2316/A1/01

CRITICAL PEER TO PEER REVIEW

Of the
**FULL PLANNING APPLICATION FOR A REPLACEMENT DWELLING
WHINNEY CLOSE FARM, KIRKHEATON**

SOUTH SECTIONAL ELEVATION AS EXISTING

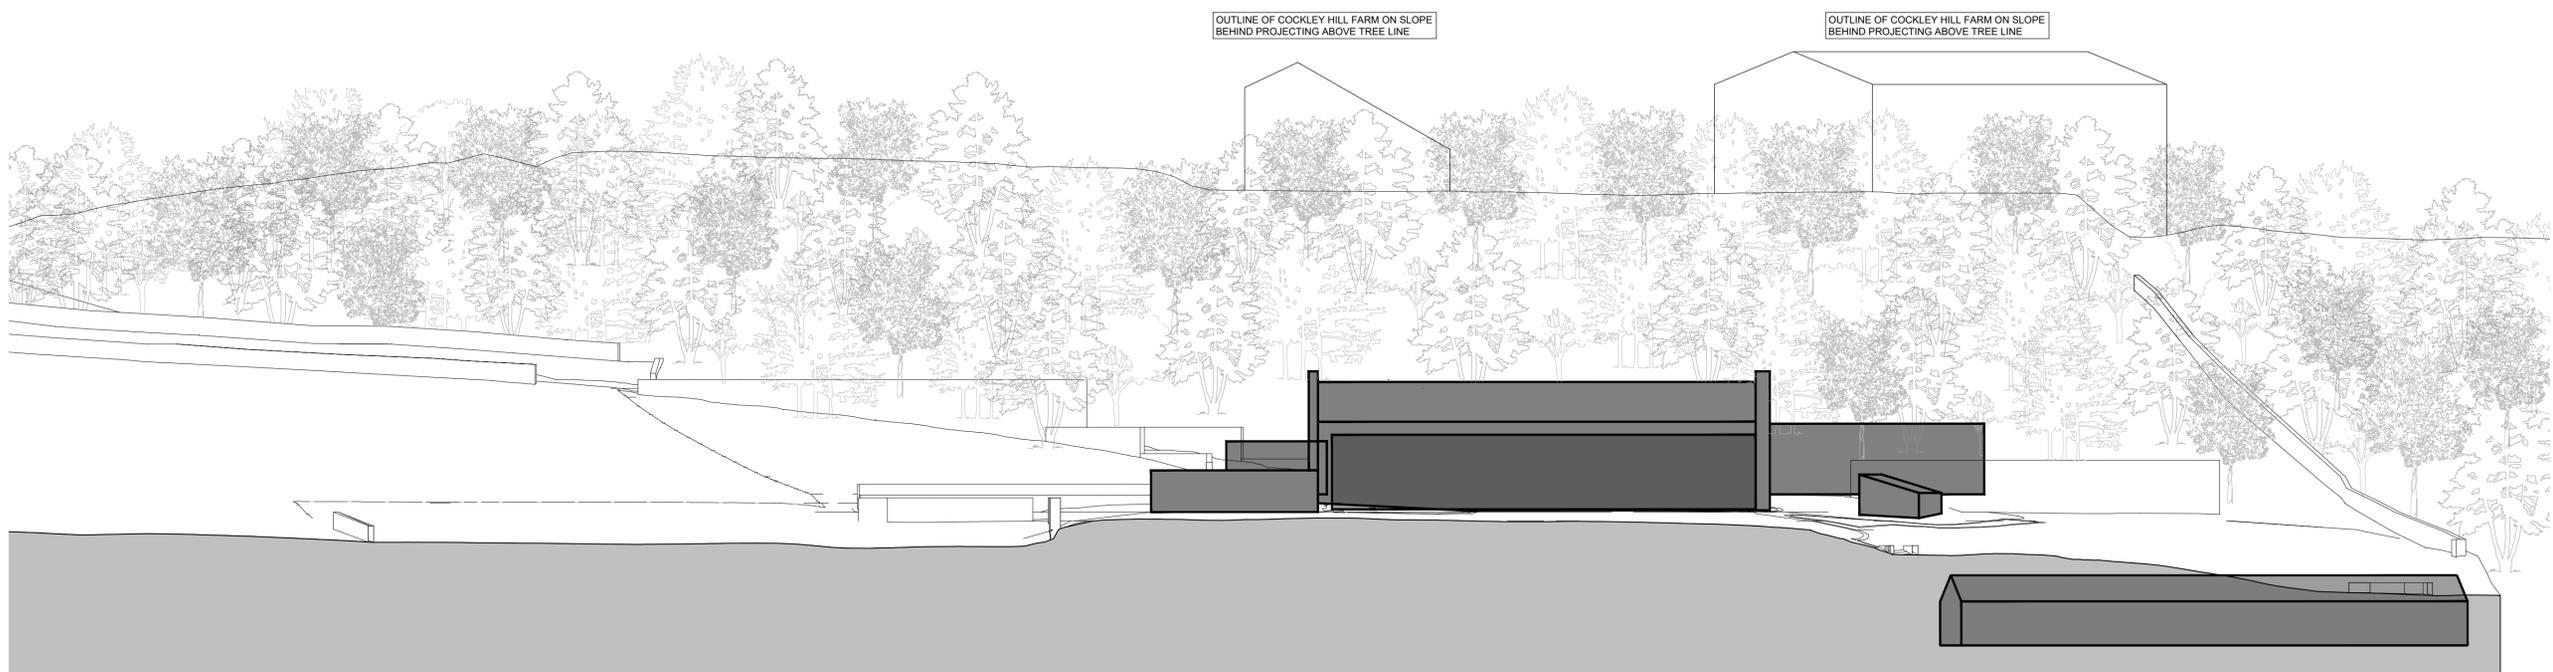
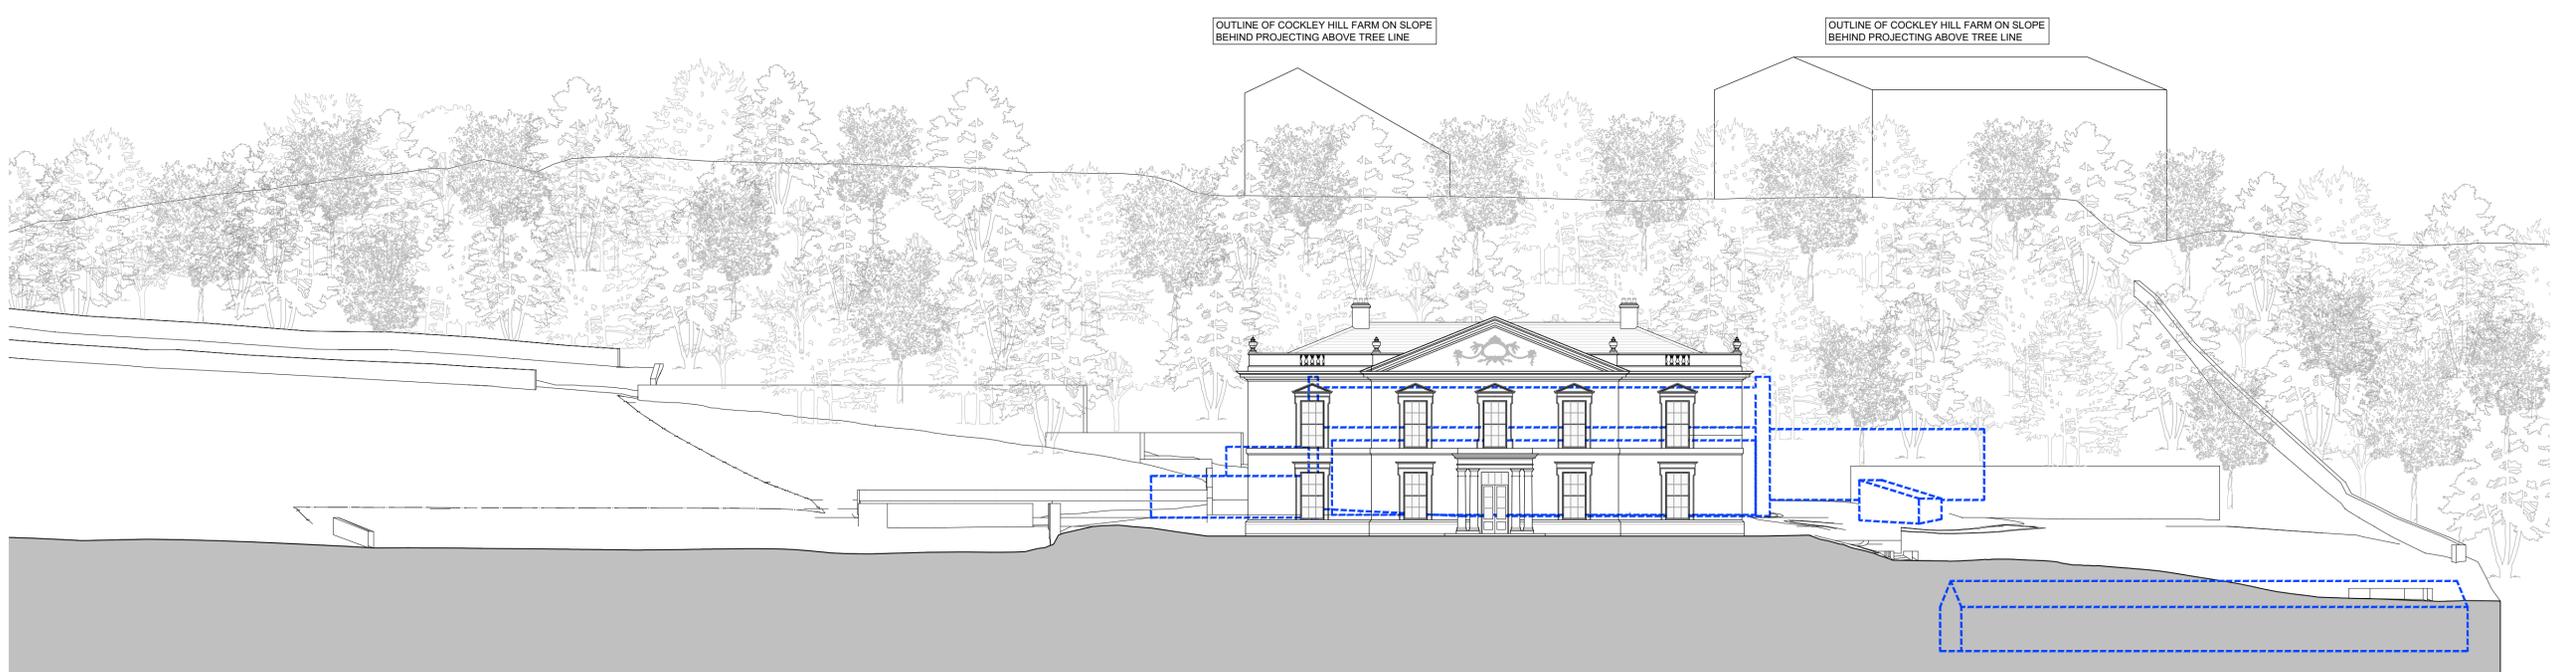
Given that the openness of the site can only be perceived from the south, I consider a key measure of the replacement dwelling's impact on the openness of the Greenbelt to be its impact from this direction. Both the existing dwelling and the replacement dwelling are seen as silhouettes against the backdrop of the wooded escarpment.

The south elevation of the current dwelling has an area of 232 square metres measured from grade. The south elevation of the replacement dwelling has an area of 323 square metres, representing an increase in area of 39%. If the applicant were to consider lowering the plateau on which the replacement dwelling is located by 900mm such that the southeast corner of the plateau is no longer elevated but also at grade, the area of the south elevation would reduce to 296 square metres representing a 27.5% increase in area.

Figure 1.7 Existing & Proposed South Elevation (Not to scale)

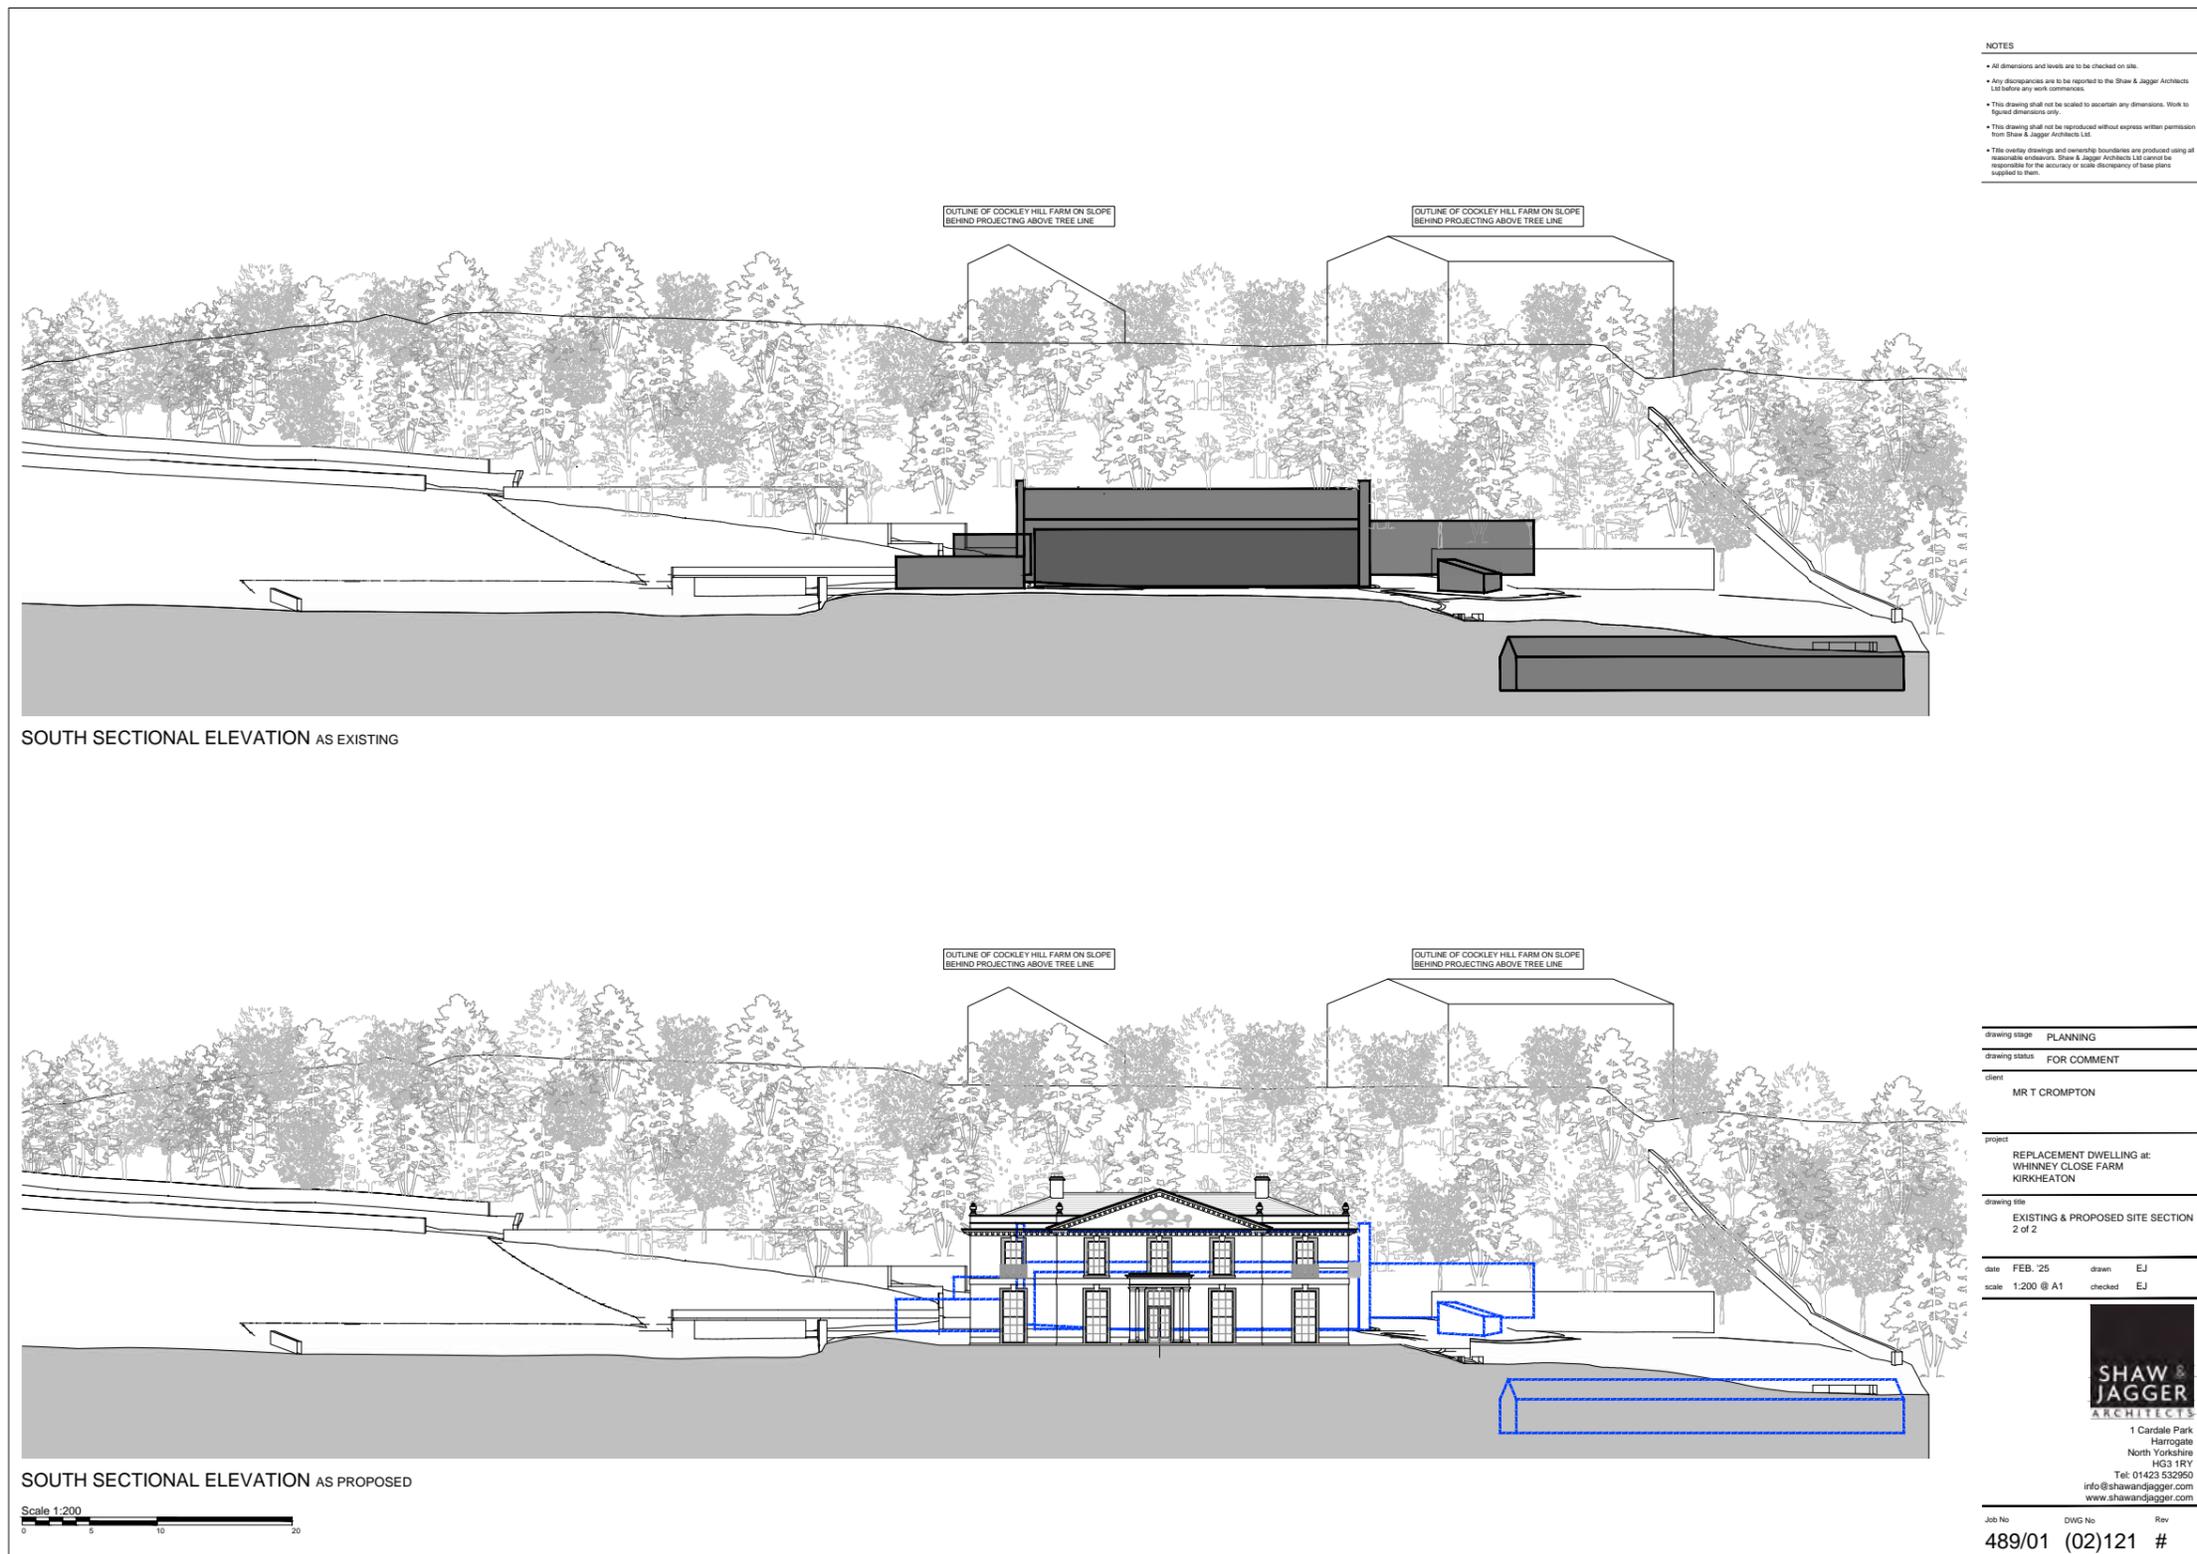
I do not consider either of these percentage increases to be materially larger than the building being replaced, therefore both satisfy the requirements of LP57.
